**Yorkshire Water Services**  
**Developer Services**  
**Sewerage Technical Team**  
**PO BOX 52**  
**Bradford**  
**BD3 7AY**

**Your Ref: 2023/91116**  
**Our Ref: Z002461**

**1st June 2023**

**Land off Primrose Lane, Hightown, Liversedge – Erection of 67 dwellings**

Drawing
Soft Landscape Plan

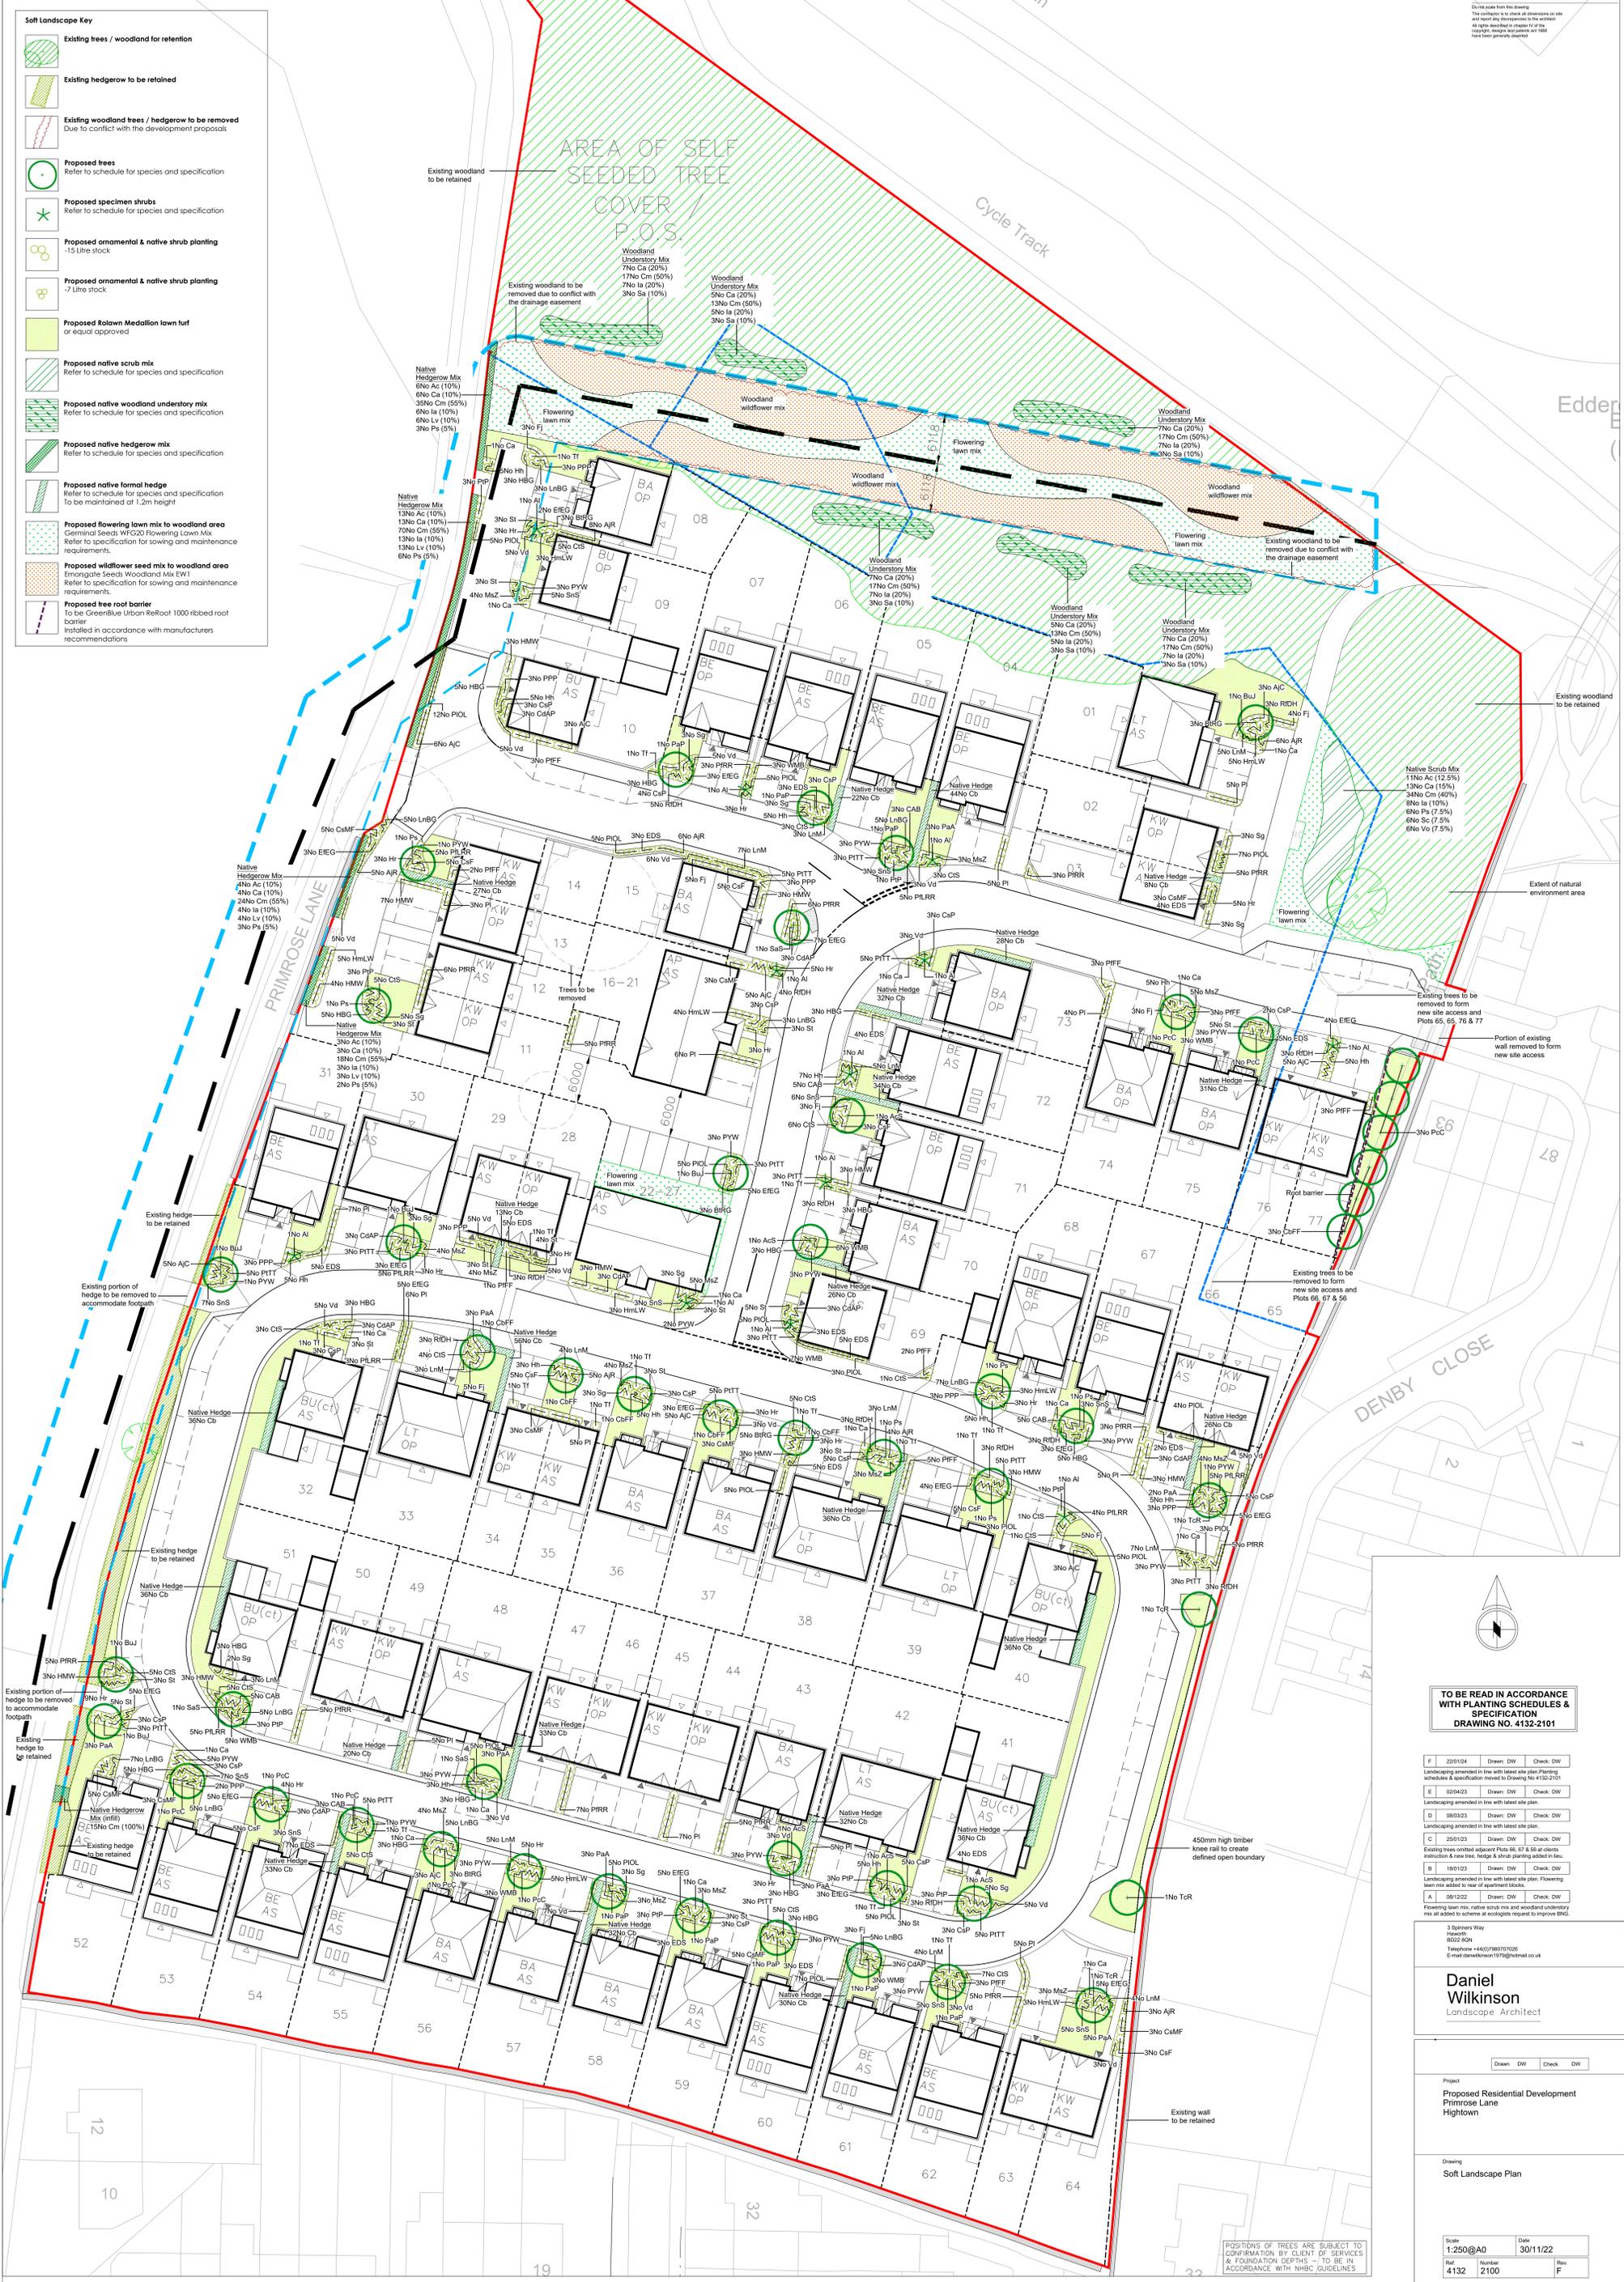
1.) The layout and landscaping details submitted on drawing 'Soft Landscape Plan' 4132 2100 (revision E) dated 02/04/2023 that has been prepared by Daniel Wilkinson is not acceptable. The following point(s) should be addressed:

a.) the submitted drawing appears to show a building proposed to be built-over the line of public watermain

- b.) the submitted drawing should show the site-surveyed position of the public watermain crossing the site.
- c.) the submitted drawing should show the required watermain legal easement - or agreed alternate scheme
- d.) the submitted drawing appears to show new tree planting within 6 metres of the public water main
